Geoffrey Sloan Associates

RE: Application for a non-material amendment to the approved applications at Charter Court, Linden Grove, New Malden, KT3 3BL.

I am writing in regards to the application for a non-material amendment to Royal Borough of Kingston upon Thames (RBK) planning approval 17/14632/FUL at Charter Court. The application proposes four changes to the approved scheme along with some general revisions to the elevations which are considered non-material in nature, these consist:

Drawing No	<b>CC319/211/G</b>
DATE	<b>18-06-18</b>

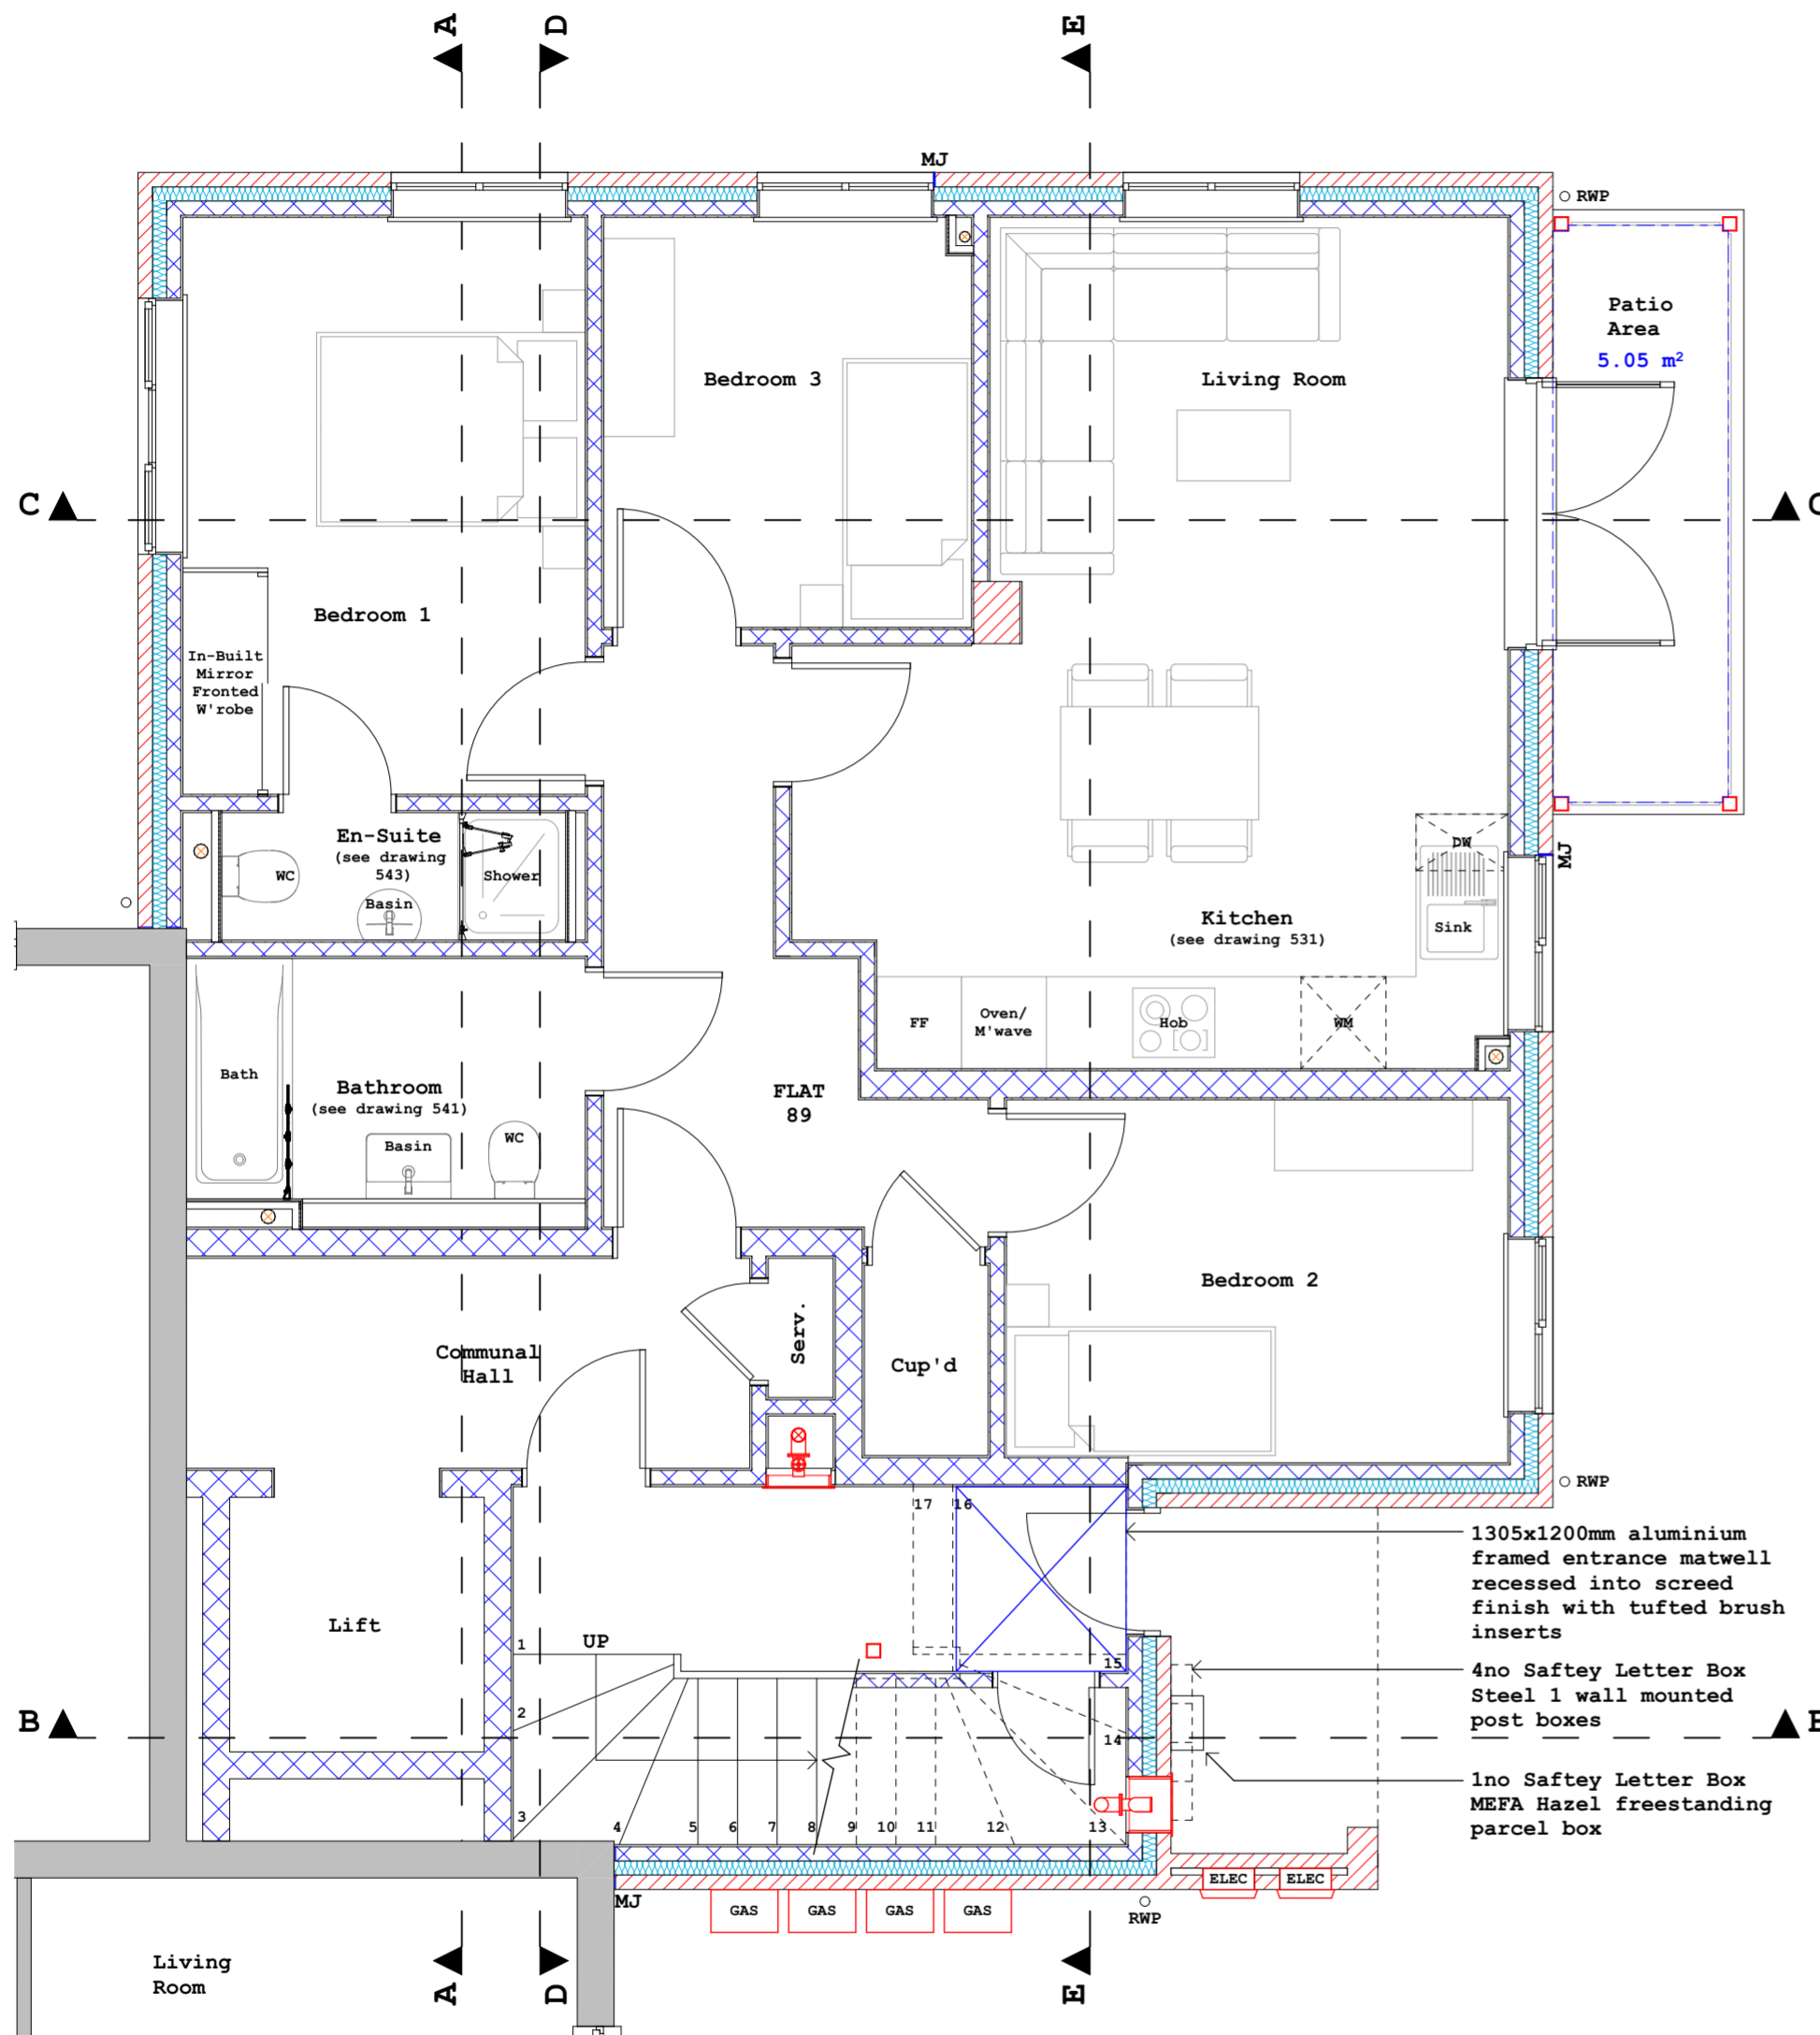
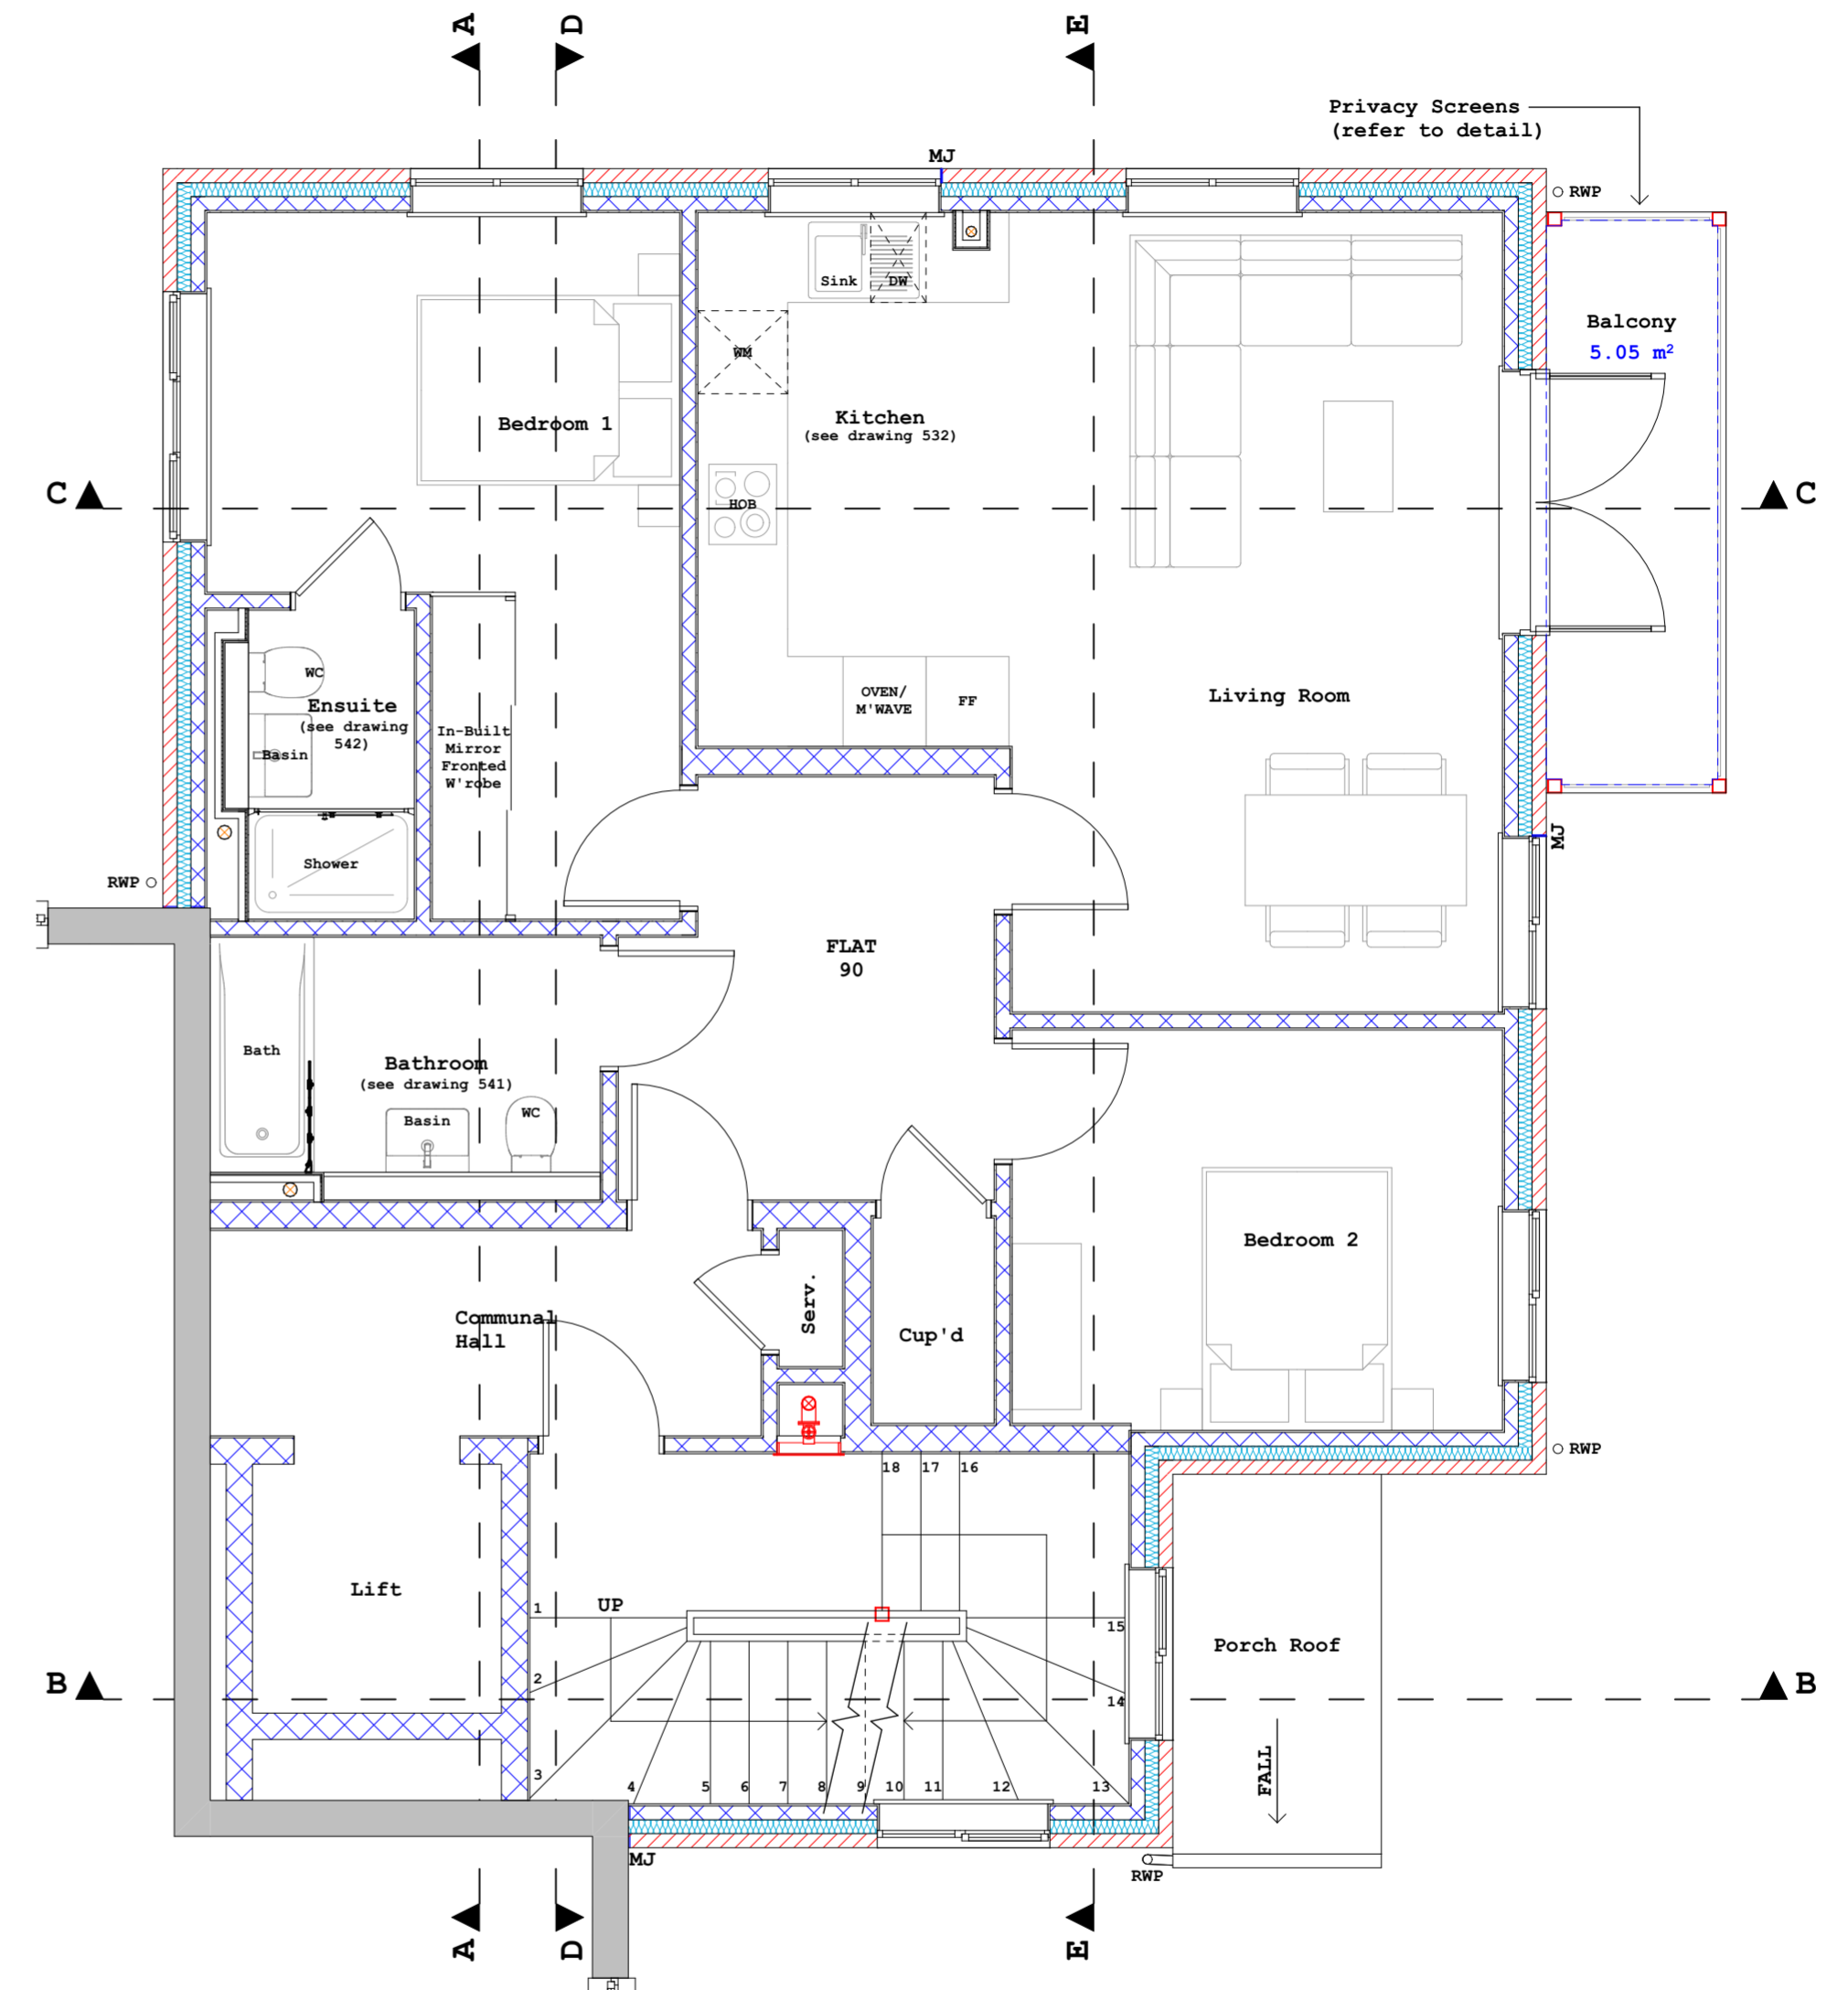
1. Reconfiguration of the ground floor layout

The ground floor layout of the building has been reconfigured to provide a new open plan kitchen and living room area. The revision to the ground floor layout aims to match the specification of the upper floor flats which incorporate an open plan layout as originally approved.

2. Alteration of ground floor windows to suit revised layout

Provision of an open plan kitchen and living room in the ground floor flat required the position of the kitchen and third bedroom to be swapped. This relocates Bedroom 3 to the side (North) elevation of the property and kitchen to the front (East) elevation of the property. Originally the kitchen was provided with a reduced height window to provide a splashback to the worktop. This has been omitted in favour of making the worktop level with the window cill. As such window G.W.04 on the side (North) elevation which now serves Bedroom 3 has been made full height. The window now matches the adjacent windows on both sides.
